1. Application Information

a) Location / Full Address	Orbital Industrial Estate, Horton Road, Yiewsley, Hillingdon, West Drayton UB7 8JL
b) Reference No.	79689/APP/2025/2438
c) Type of Application	Full Major

2. Application Documents Received and Reviewed

4. Response from LLFA

TITLE: DRAINAGE STRATEGY SHEET 2-2

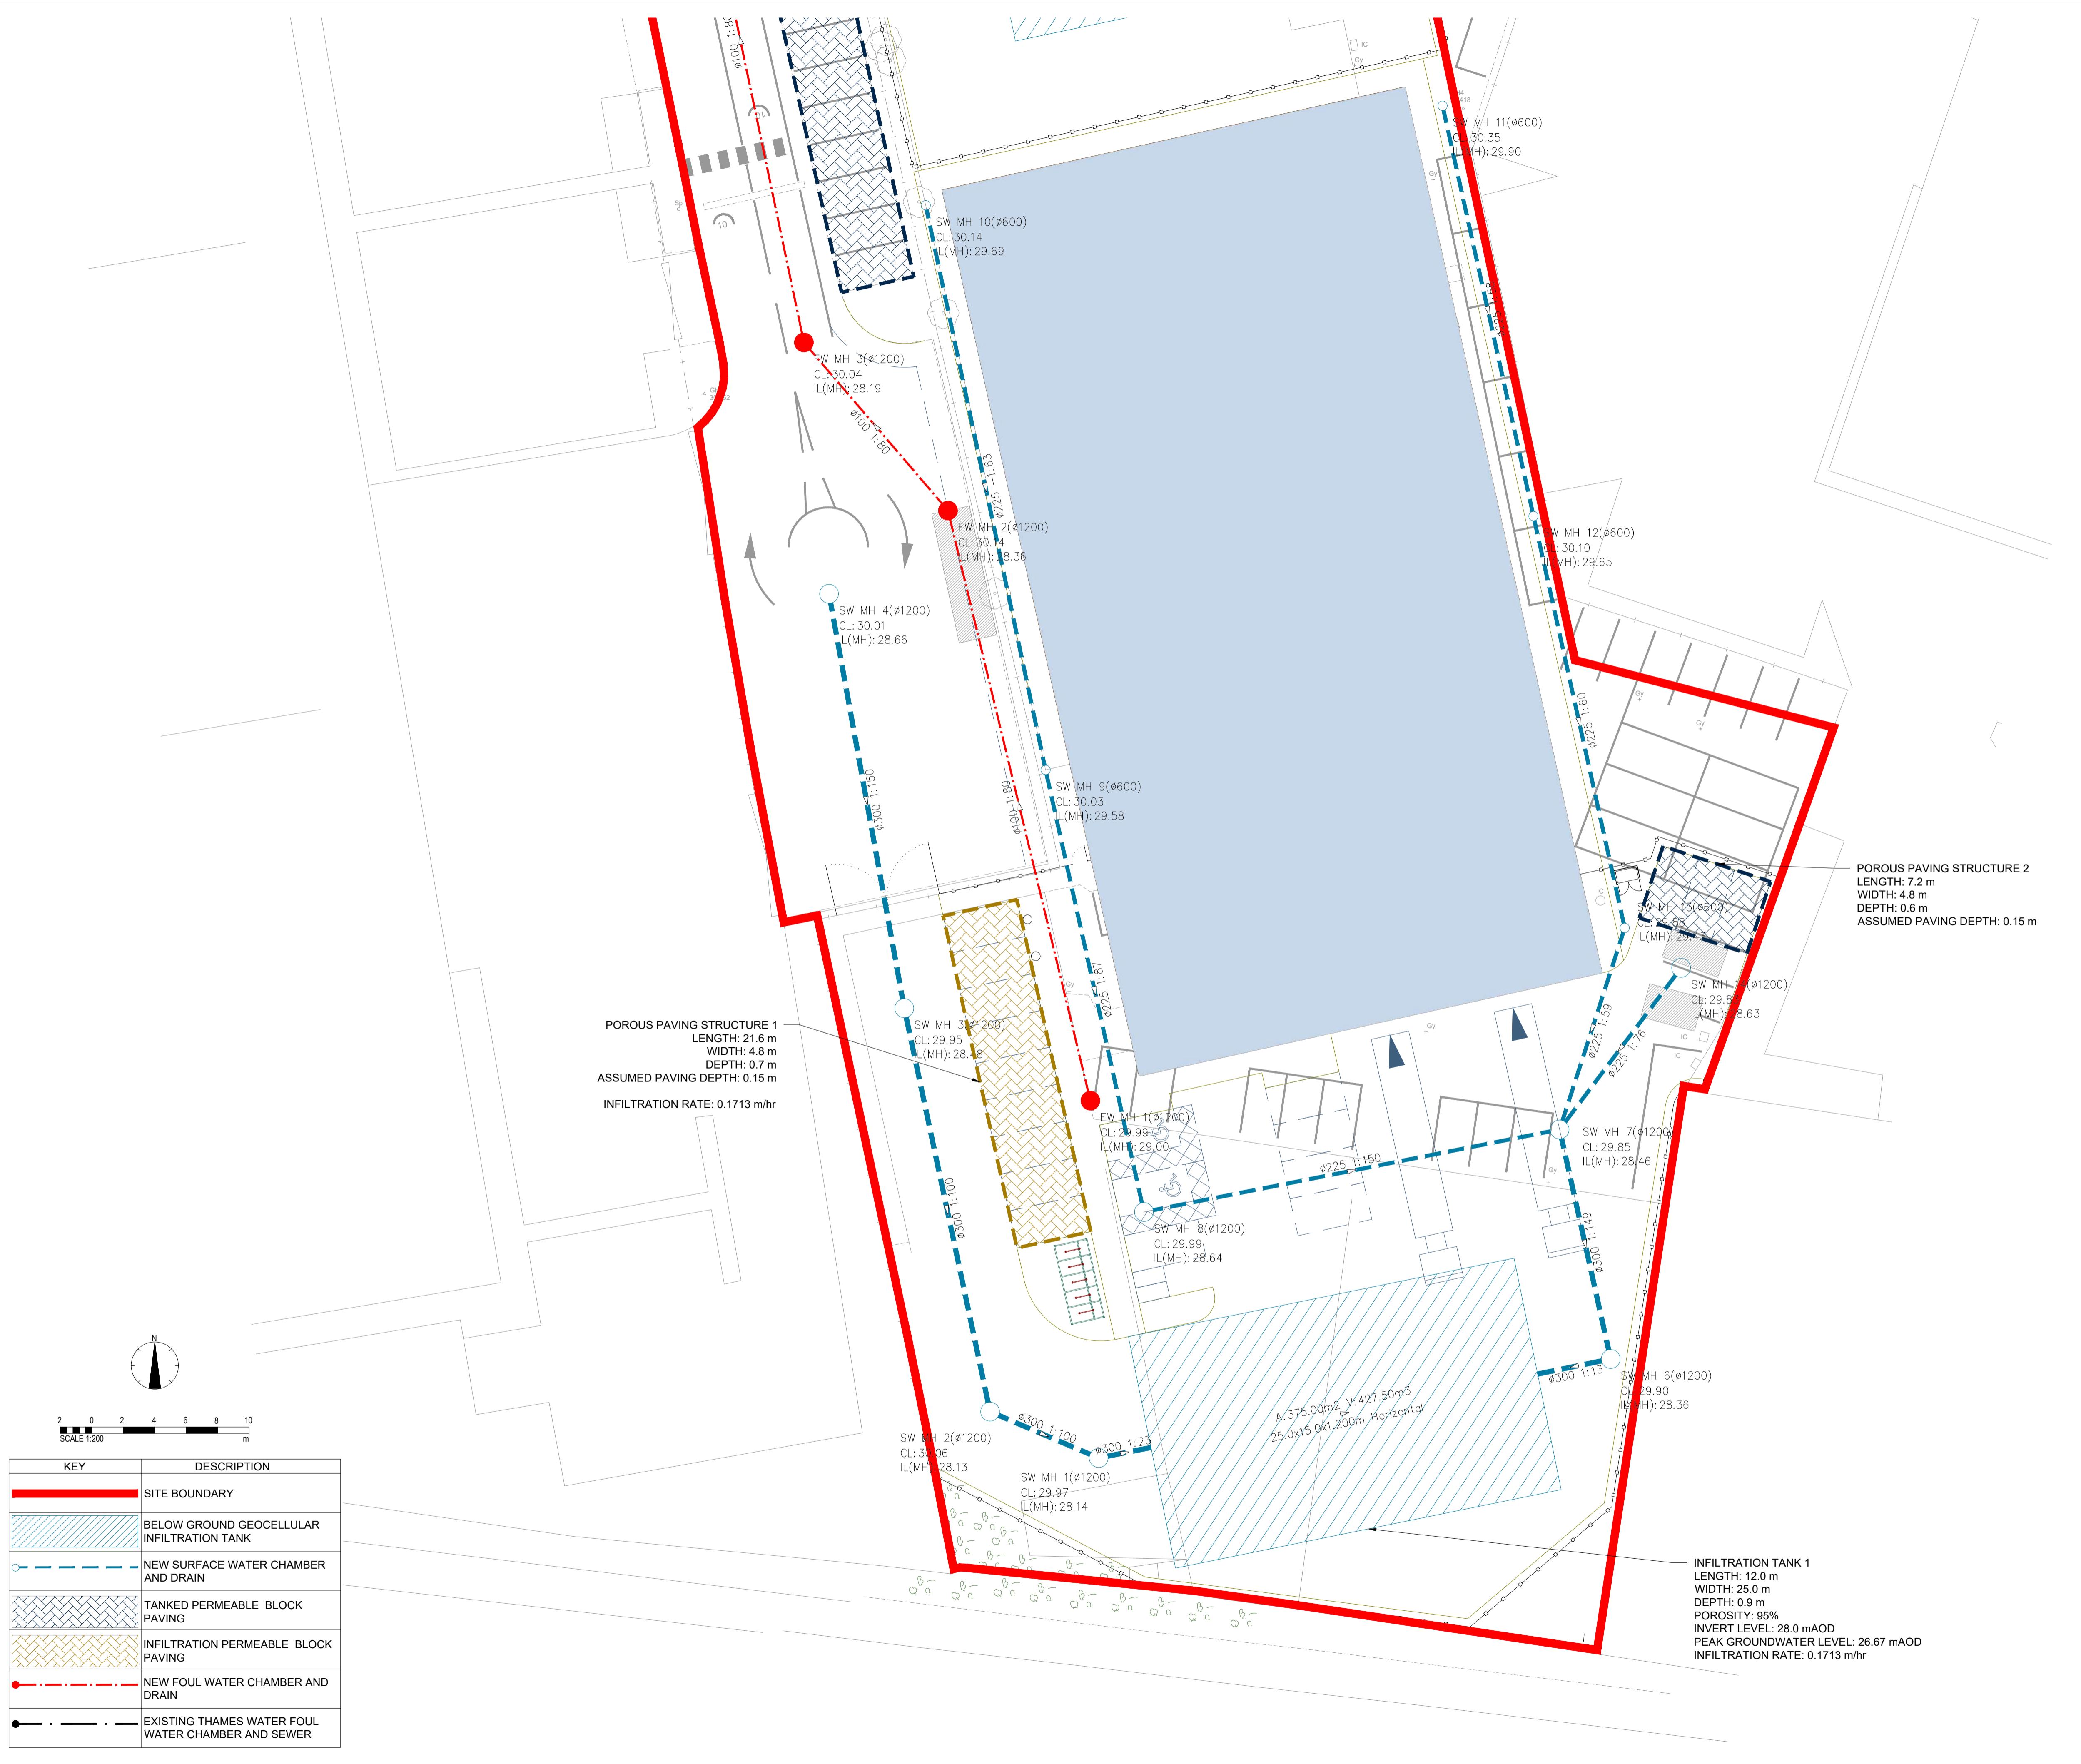
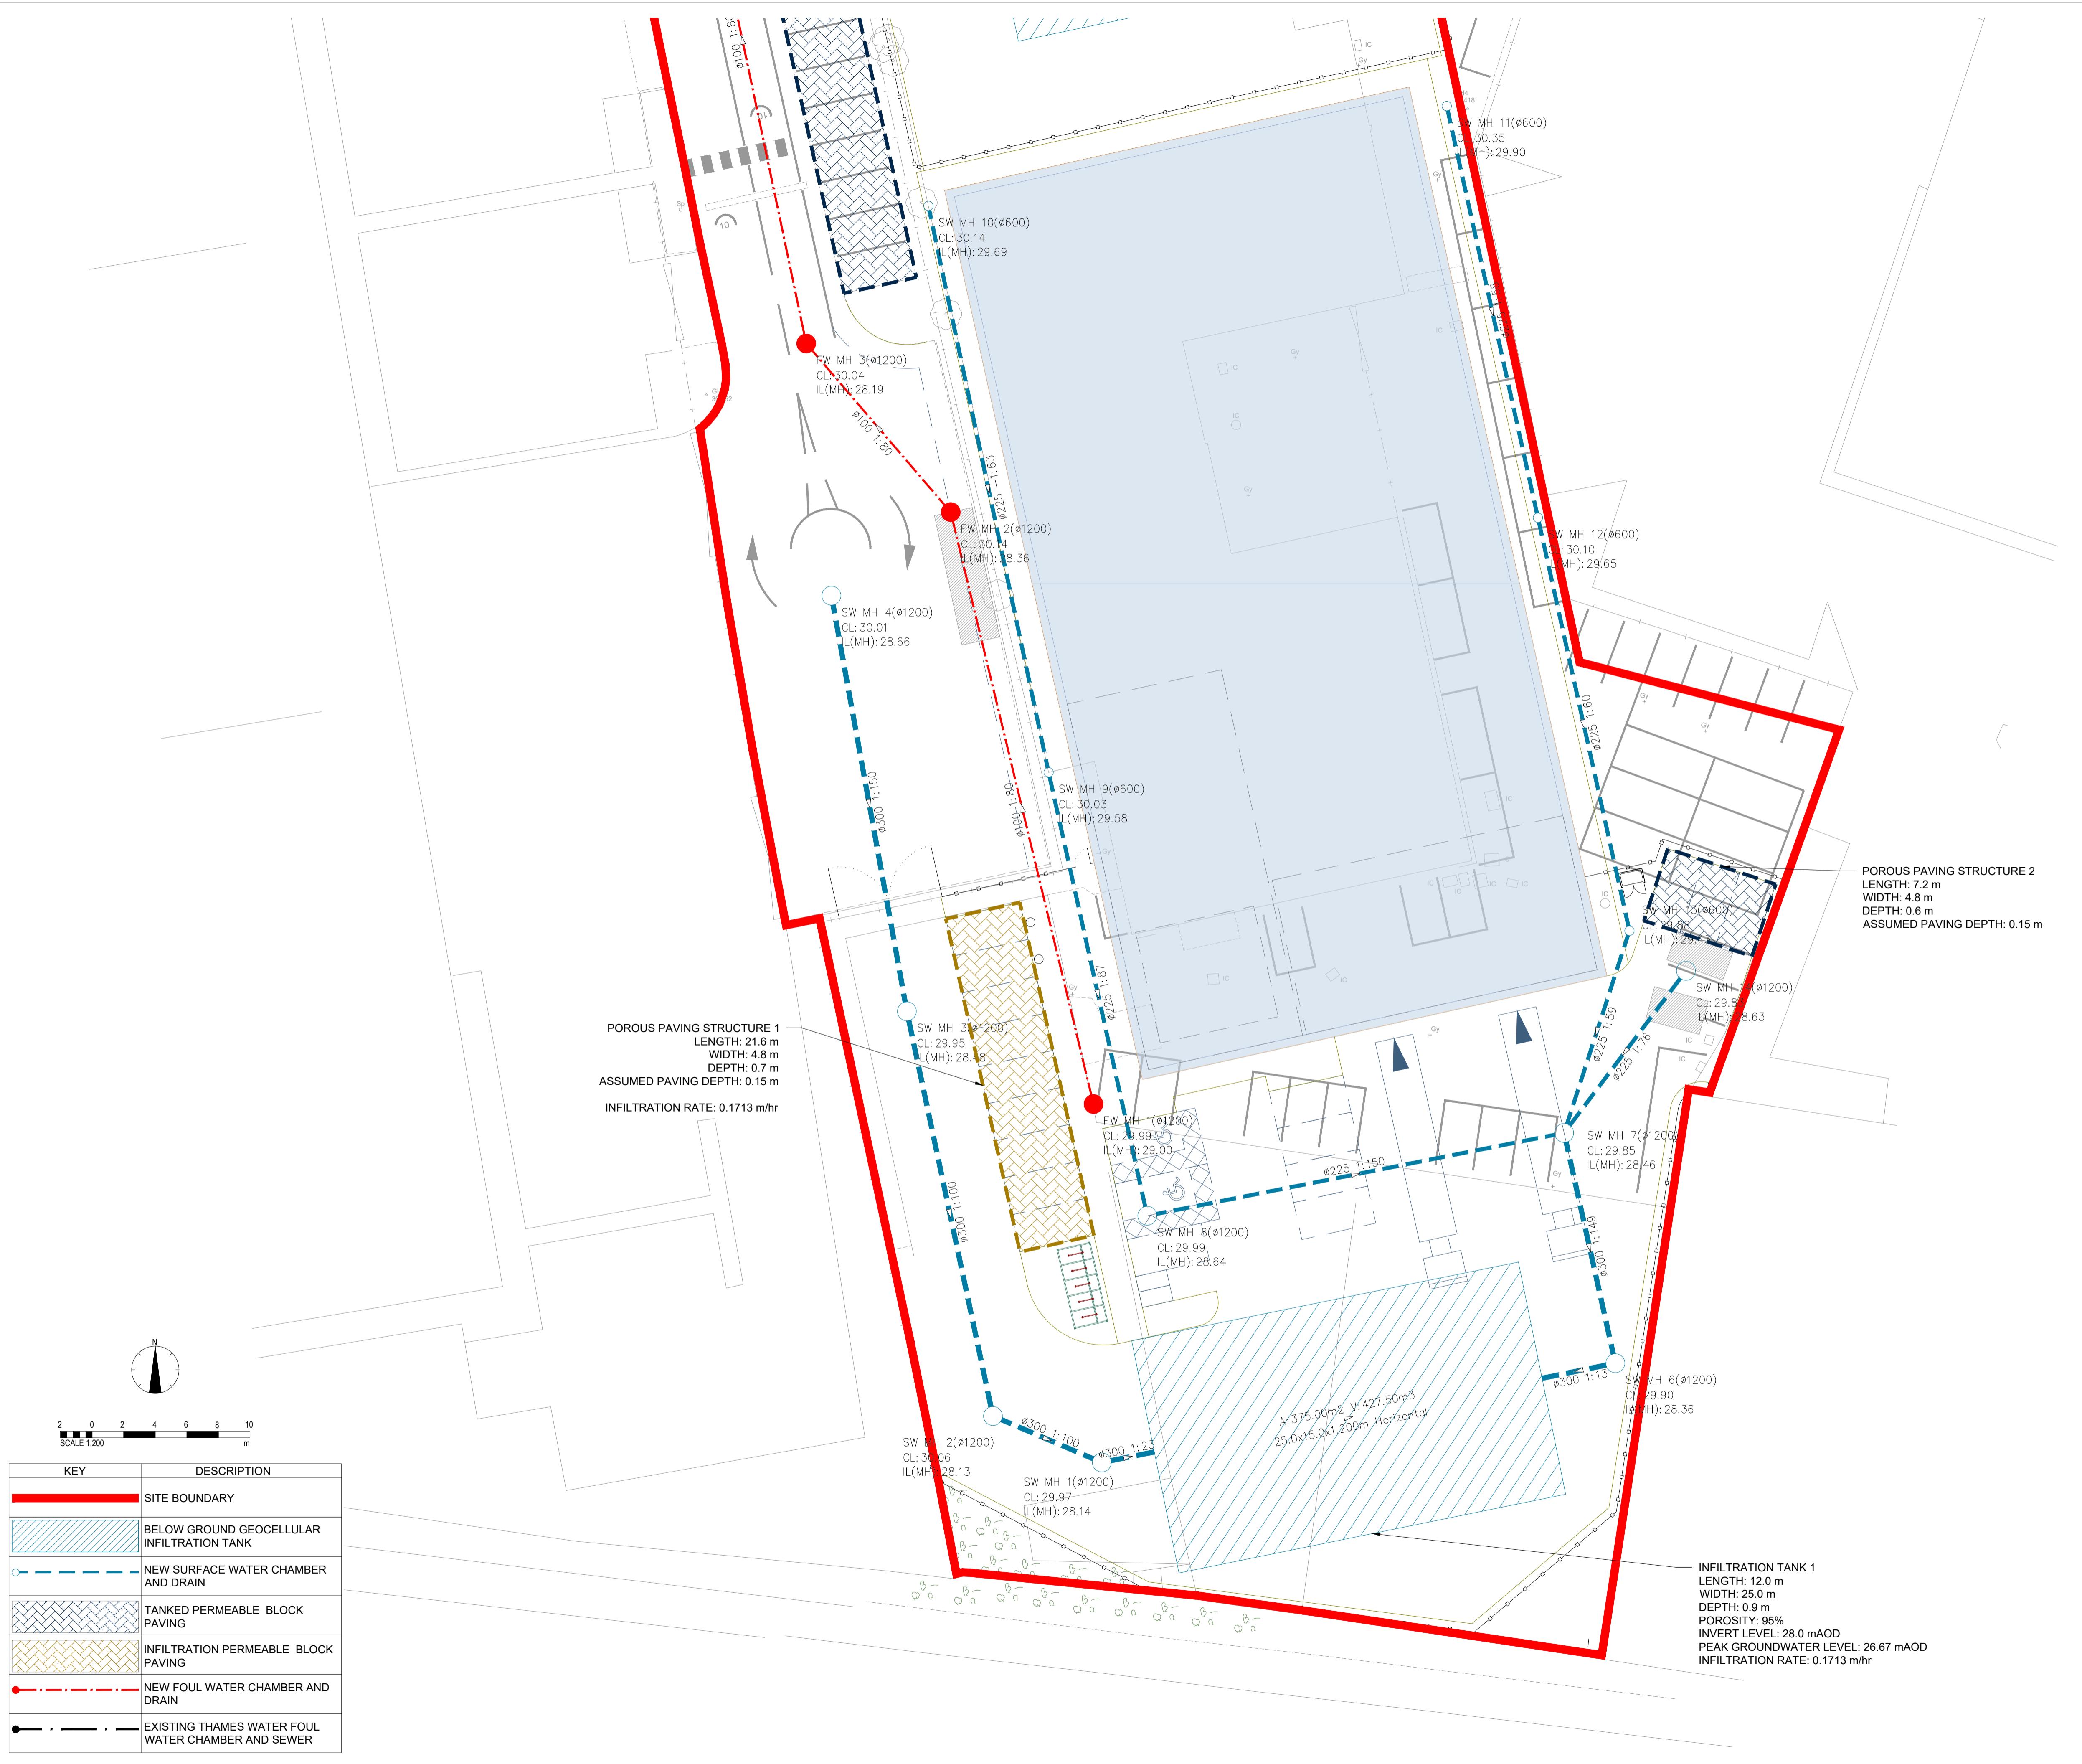
- Provide a drainage plan which shows where the petrol separators are located within the site.
- Name of the maintenance owner and considers the health and safety risks associated with the construction, operation and maintenance and decommissioning of the drainage system

Provide a drainage plan which shows where the petrol separators are located within the site.	5027861-RDG-XX-XX-T-C-000550-P03-Drainage Strategy (p.44 & 45)	The applicant has now included petrol separators on a site drawing, along with the other proposed SuDS.	PASS – The location of the petrol separators are included in the drainage drawings.
		Name of the maintenance owner and considers the health and safety risks associated with the construction, operation and maintenance and decommissioning of the drainage system.	5027861-RDG-XX-XX-T-C-000550-P03-Drainage Strategy (P.21 & 24)	Maintenance confirmed to be undertaken by the site landlord, LMO Overseas Investments Limited, for the duration of use. It is stated that the contractor/maintenance provider should develop a risk assessment and method statement prior to the	PASS – The name of the maintenance owner has been provided, and health and safety risks associated with the construction, operation and maintenance and
